Sanctuary of Peace Cohousing Community at Benet Hill, PUDSP-19-002

Please accept the following comments from El Paso County Public Health (EPCPH) regarding the 49.58-acre, 27-commercial/residential lot development project referenced above:

Mike McCarthy
El Paso County Public Health
719.575.8602
mikemccarthy@elpasoco.com
03Dec2019

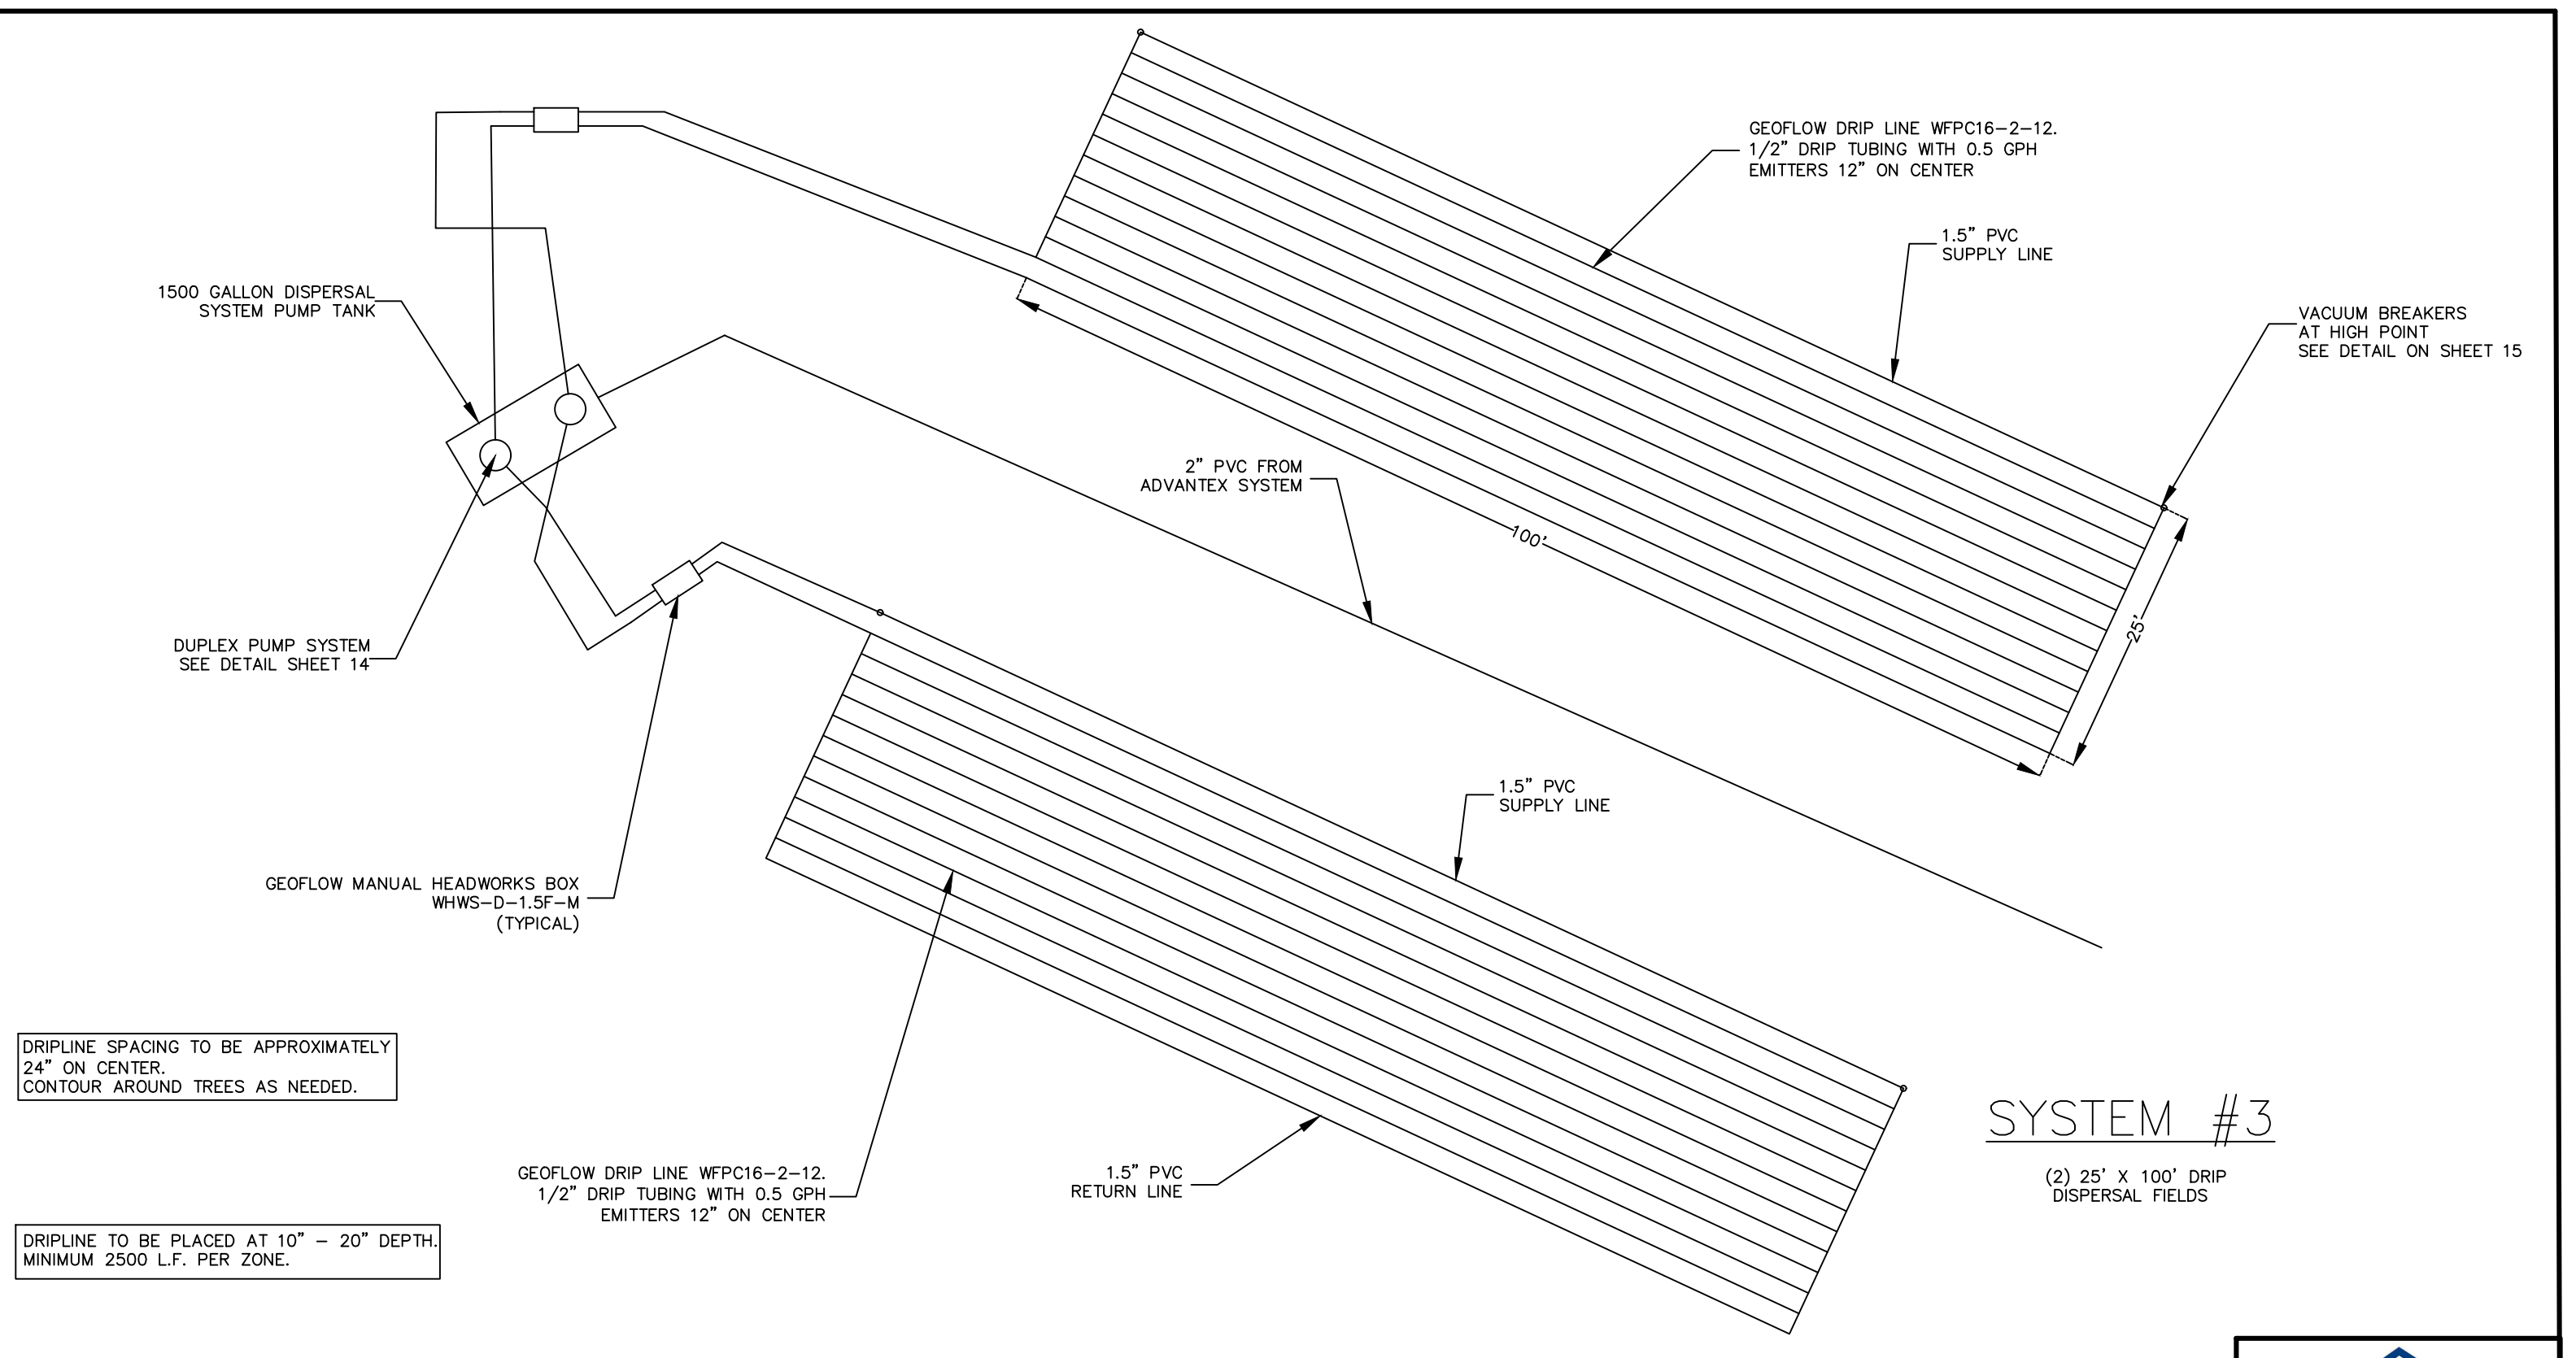
- **Note: The 285 Engineering, 18June2018, OWTS design shows the proposed well zone of influence circle with a radius of 50', but must be 100' minimum, and 8' of additional distance for each 100 gallons of wastewater flow over 1,000 gallons; therefore, the radius for the proposed well must be 140' from the zone of influence from the closest soil treatment area (appears to be soil treatment area 3).**

Response: The 50-foot radius on sheet 7 of the 285 Engineering design is for the separation distance requirement to sewer pipes. Any sewer pipe within this 50-foot radius needs to be encased per Table 7-1, footnote 2 of the El Paso County OWTS Regulations. The separation distance / zone of influence radius around the soil treatment areas is depicted on sheet 2 of the 285 Engineering design. The 200-foot zone of influence around the soil treatment areas satisfies the separation distance requirements in Table 7-1, footnote 3 of the OWTS Regulations, and the zone of influence requirements of the WQCD Policy 6.
